From: Sue Howell <Sue.Howell@arun.gov.uk>
Sent: 20 July 2020 16:27
To: Planning.Responses <Planning.Responses@arun.gov.uk>
Cc: Raymond Cole <Raymond.Cole@arun.gov.uk>
Subject: RE: Planning Consultation on: P/57/20/DOC

Application ref: P/57/20/DOC

Description: Approval of details reserved by condition imposed under ref P/30/19/OUT relating to Condition No 6 - design code masterplan.

Location: Land north of Hook Lane Hook Lane Pagham Bognor Regis

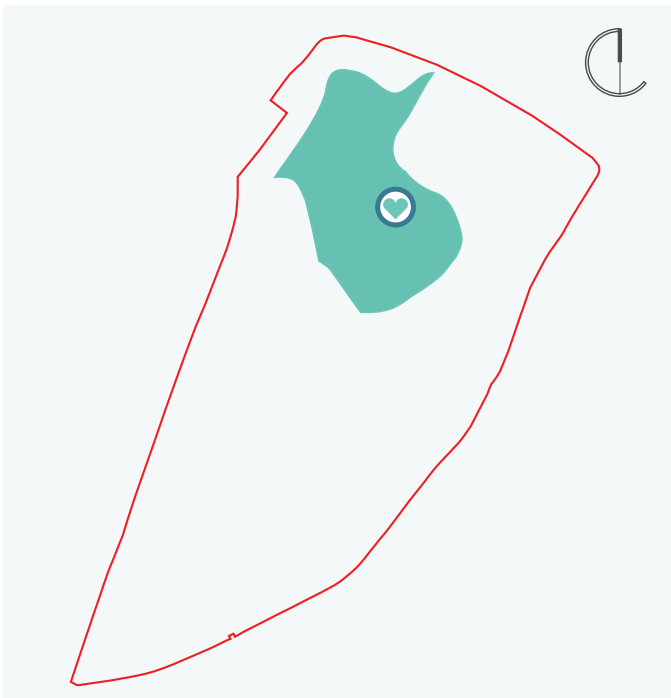
1. *'The rife watercourse will have boulders strategically placed along its route to provide informal play opportunities'* and *'The watercourse, swales and attenuation basins will be designed to have pleasing naturalistic form to ensure safe exploration'* This is an element of the design code that we would **NOT be able to support**. Play opportunity within potential wet or dry SuDS features must not be included on safety grounds. Play features including within naturalised areas must be away from potential water holding bodies (even more importantly intermittent water holding bodies)

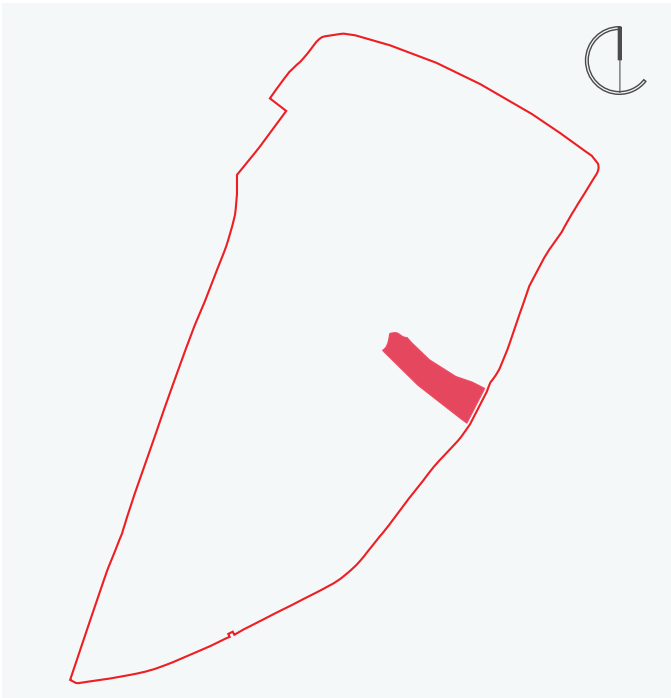
2. It is disappointing to see that there is no physical green east west continual corridor, particularly evident between Downs View and Rife Green which will be bisected by a road. It will be important therefore in such locations to allow 'hop overs' to ensure continued habitat connectivity albeit at a canopy level.
